EMAIL: SYMCA.Planning@southyorkshire-ca.gov.uk

Ref: 2026/O232

Description: *Erection of 119 dwellings, open space and associated infrastructure.*

Location: *Land to the south of Bloomhouse Lane, East of Woolley Colliery Road, Darton, Barnsley*

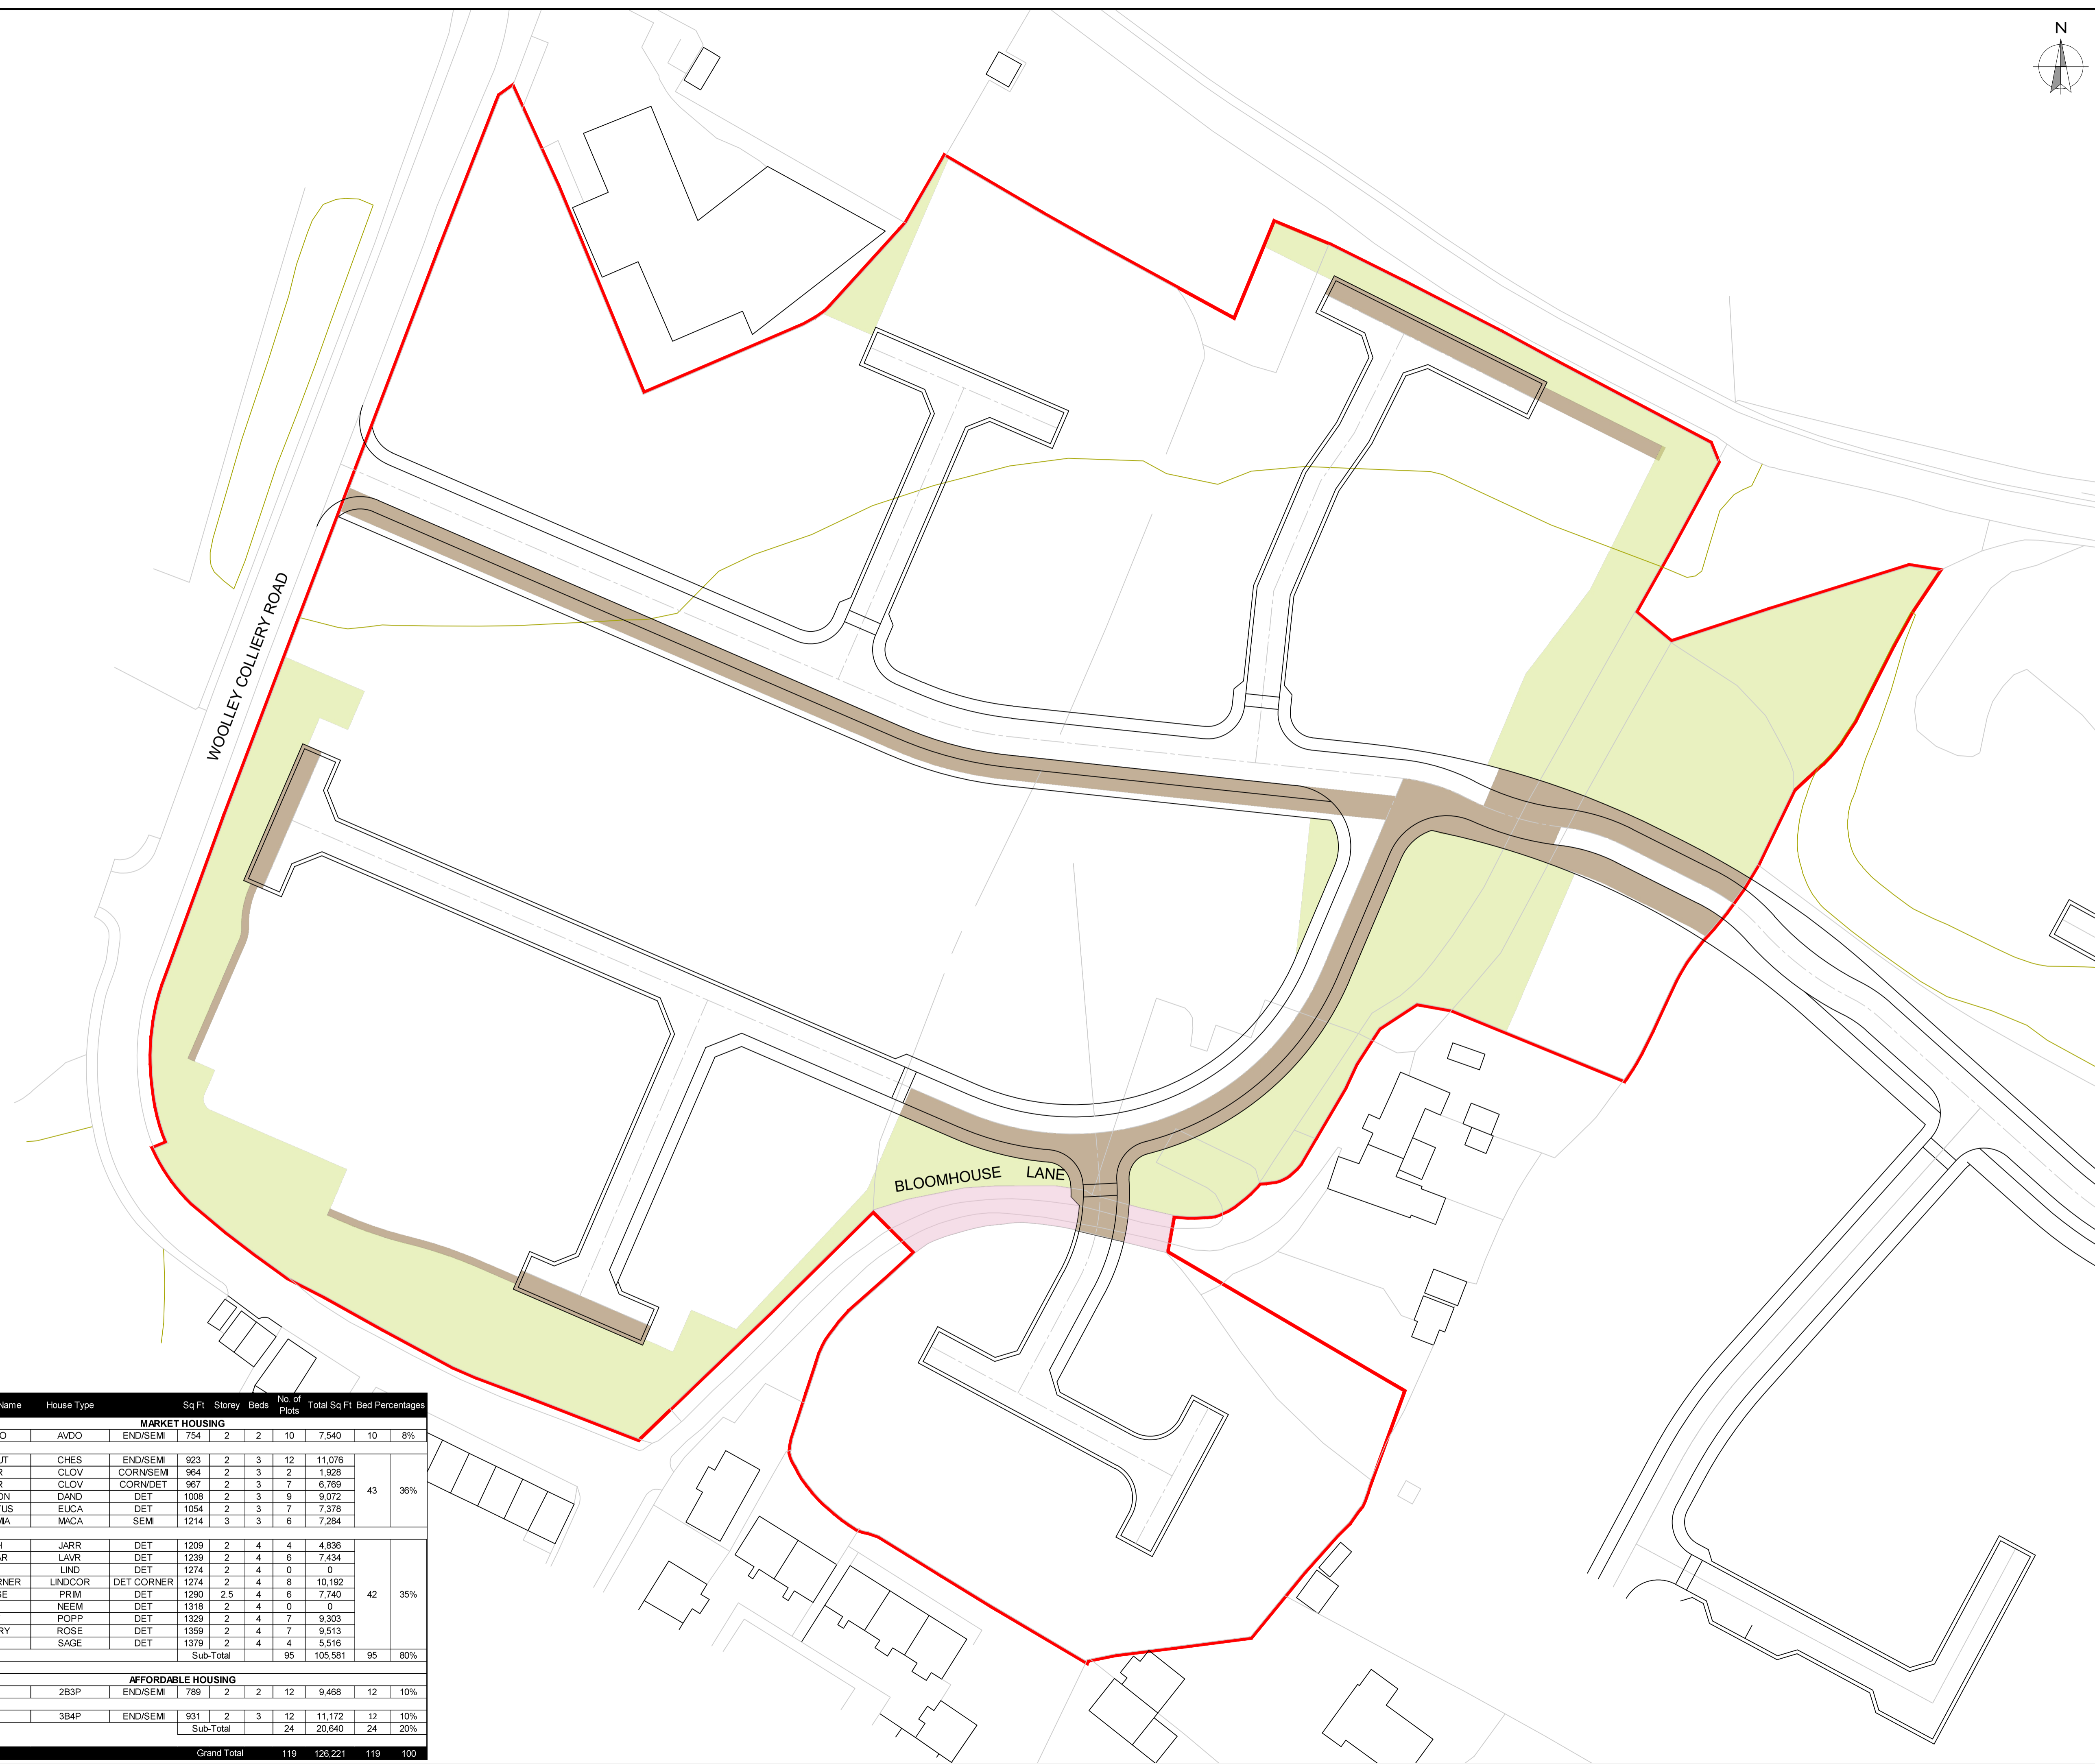
We would ask that site layout is amended to show the new inbound bus stop. Alternatively we would ask for confirmation that the proposed site access arrangements are compatible with a new bus stop in the approximate proposed location (as per Figure 6).

Site Layout drawing 25-5808-01-B appears to show existing Bridleway Darton UD 45 being improved with a 2m wide sealed surface. The Highways Act 1980 Schedule 12 1 (3) (a) states the minimum width of a bridleway should be 3m. A clear useable width of 3m should be provided for this section of bridleway and the surface should be suitable for use by horses.

It is good to see links from the end of culs-de-sac to Woolley Colliery Road however it is unclear if these are usable by bicycles. These connections should be suitable for all who walk, wheel and cycle, and should be surfaced to a minimum width of 3m with a smooth surface, fully lit and free from any access barriers.
